REPORT ON STRUCTURAL AND DRAINAGE MATTERS

PROPOSED BARN CONVERSION

**HOE BARN COTTAGE
HOE LANE
FLANSHAM
WEST SUSSEX
PO22 8NS**

Drawing Title:
Proposed Plans & Elevations

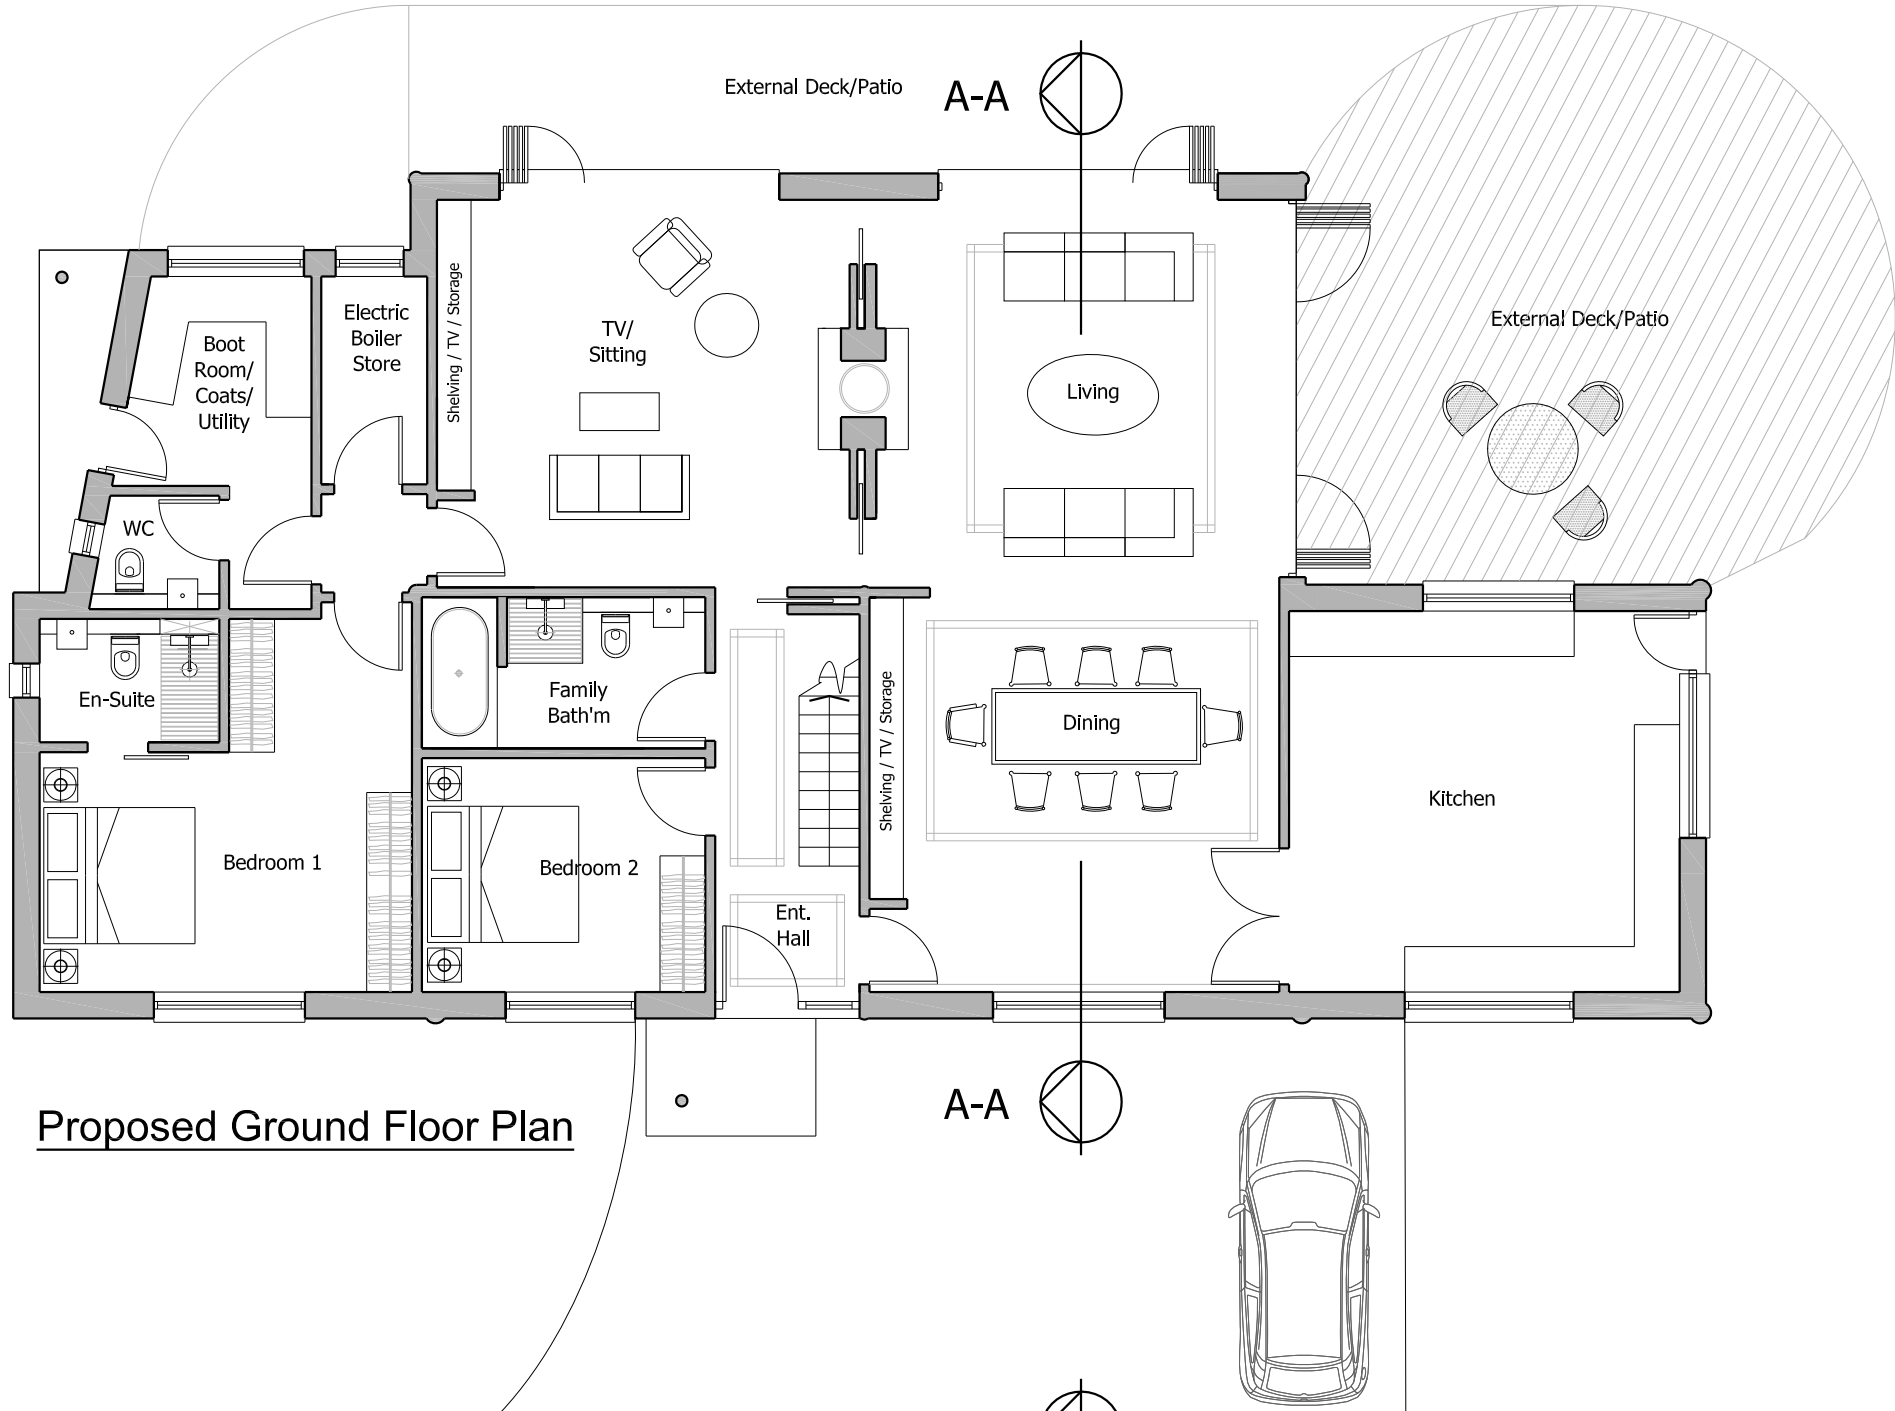
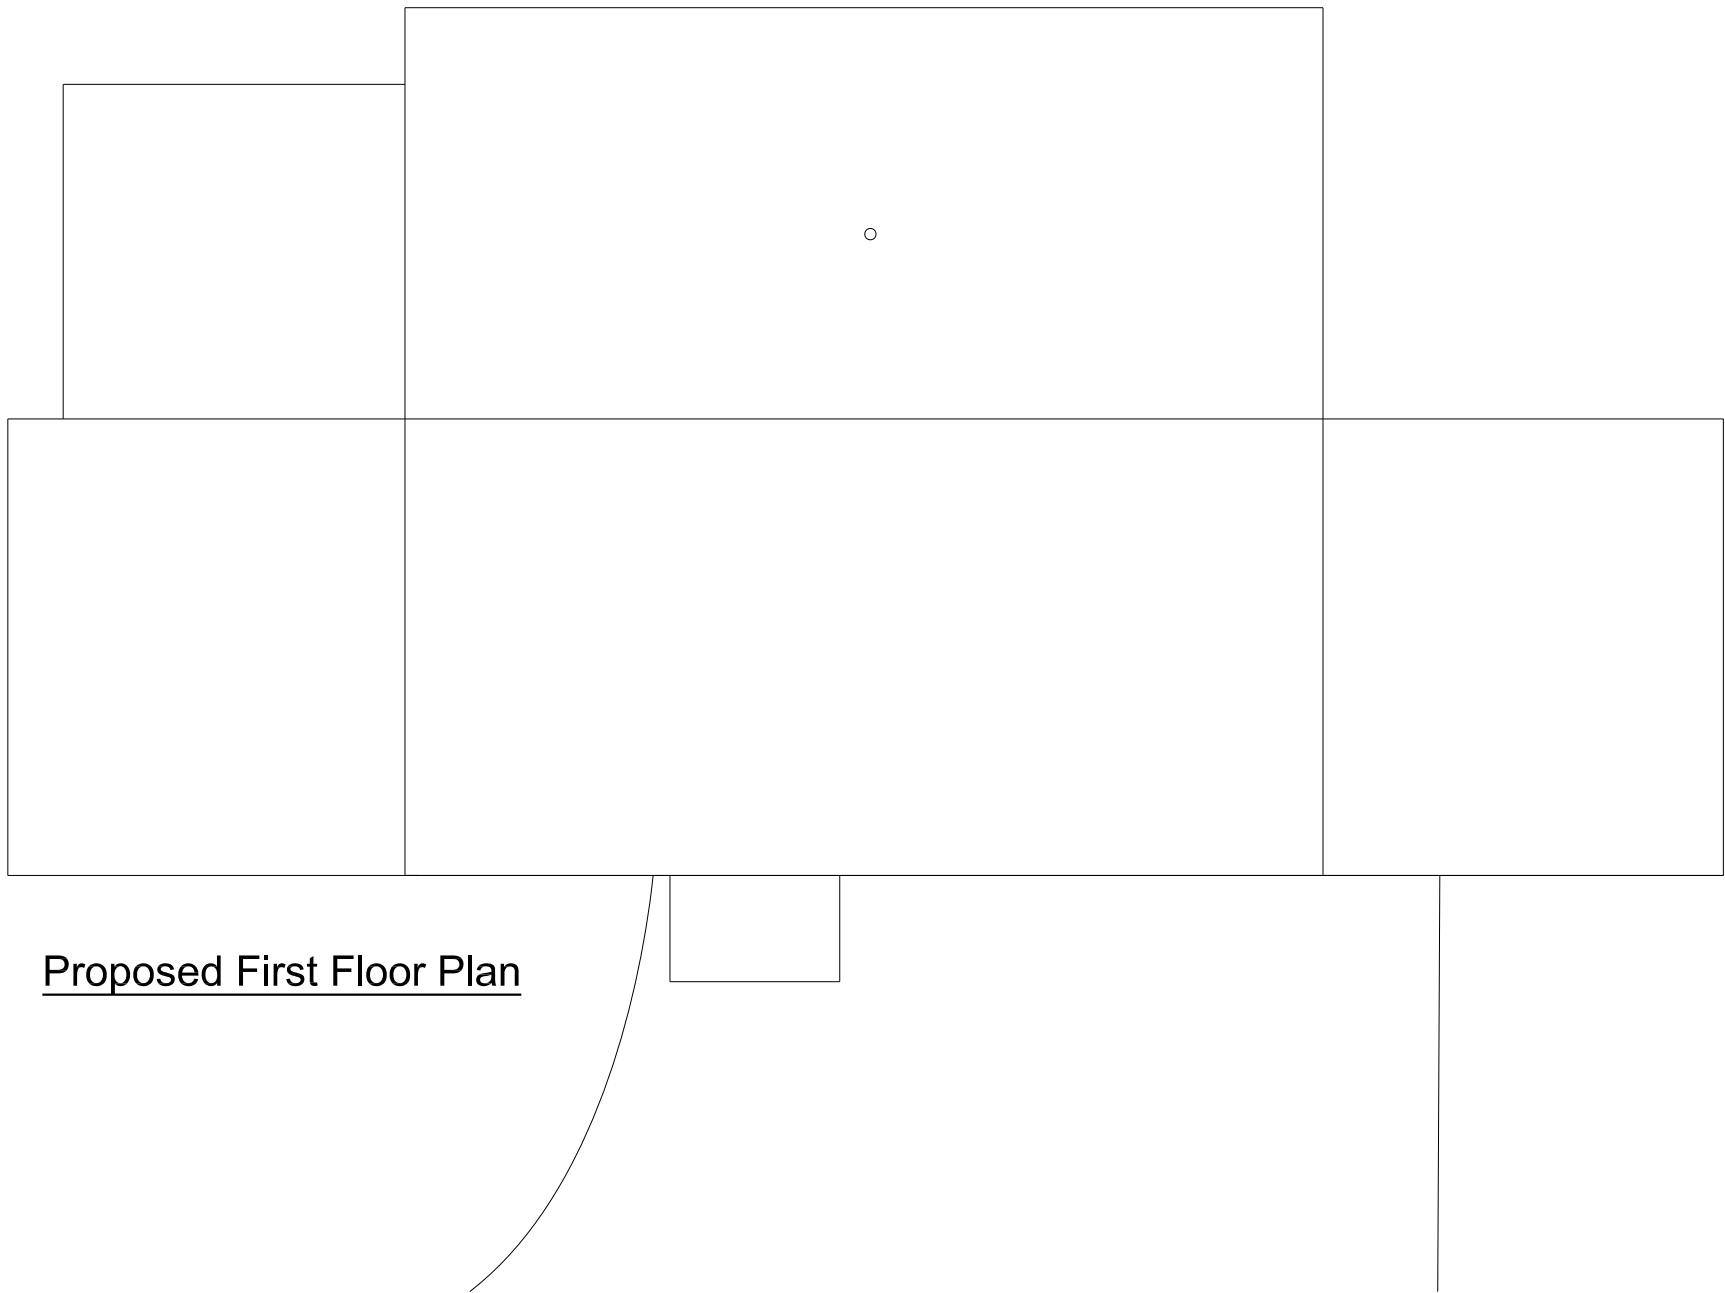
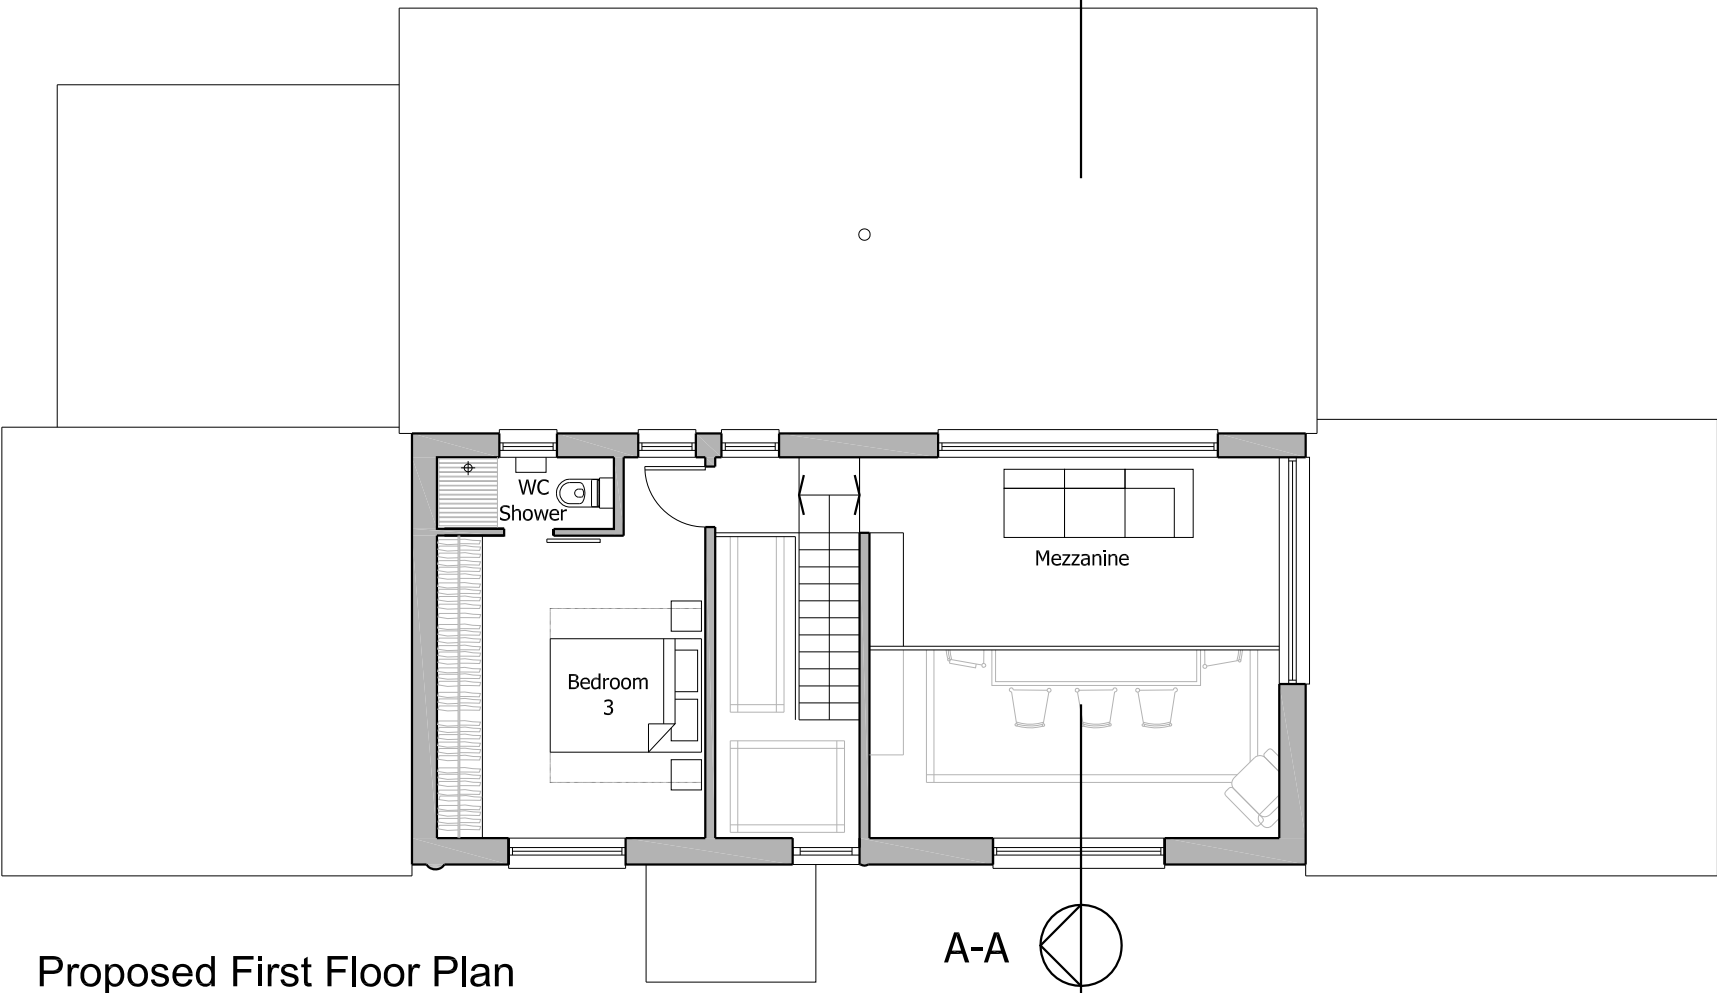
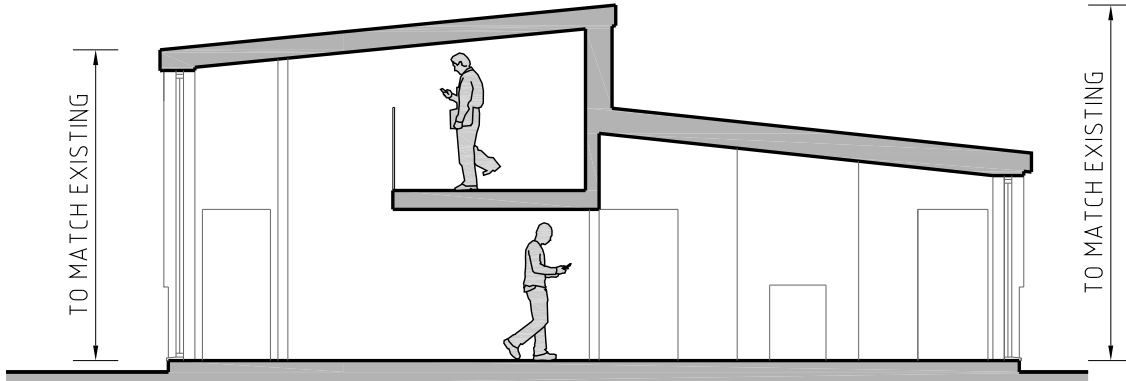
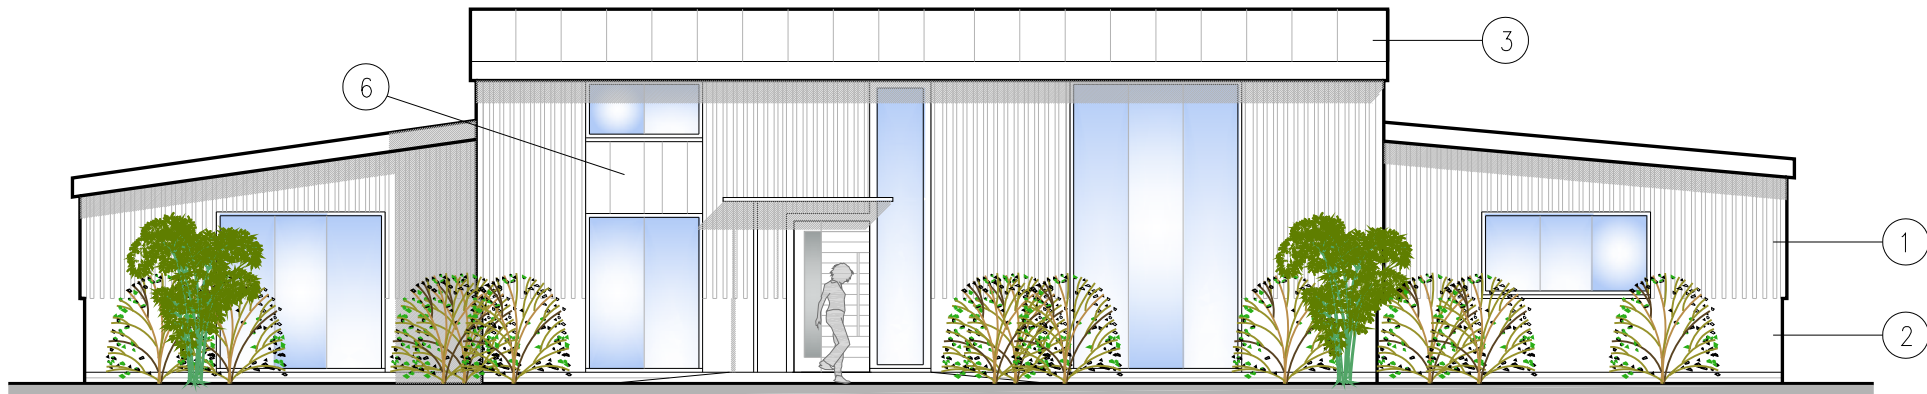
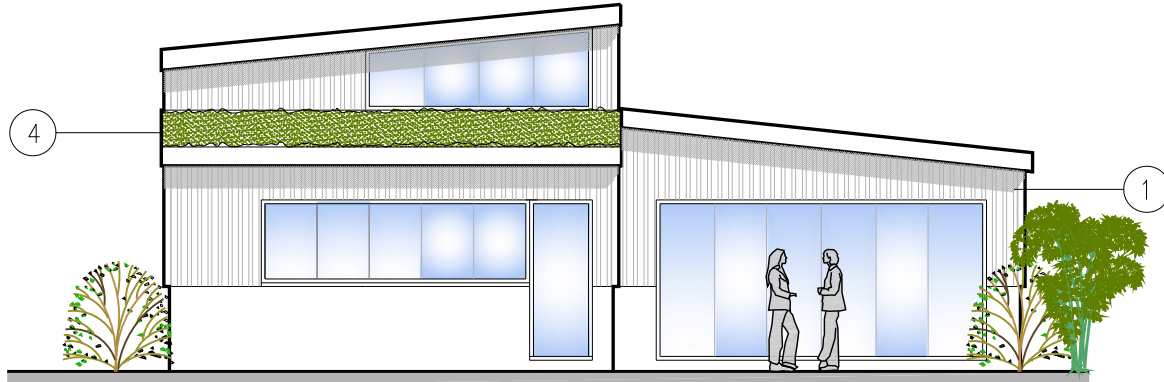
3.1 Based on our site investigation and preliminary structural considerations we would confirm that the proposed plans and elevations presented on the JJR Planning Drawing No. 1230/101 could be progressed to construction without substantial structural works to the existing building.

3.2 We would anticipate at this stage, subject to further structural inspection and analysis, the following structural measures could be required.

- Local underpinning of existing timber column foundations.
- Remedial works to the feet of some timber columns. This may comprise the replacement of timber sections locally to approximately 150mm above ground level and replacing with galvanised steelwork support shoes.
- Developing in conjunction with the Architect, new external and internal wall constructions which provide adequate racking stability to resist lateral loadings.
- Strengthening as necessary the existing timber purlins and rafters to support new insulated roof coverings, subject to design development.
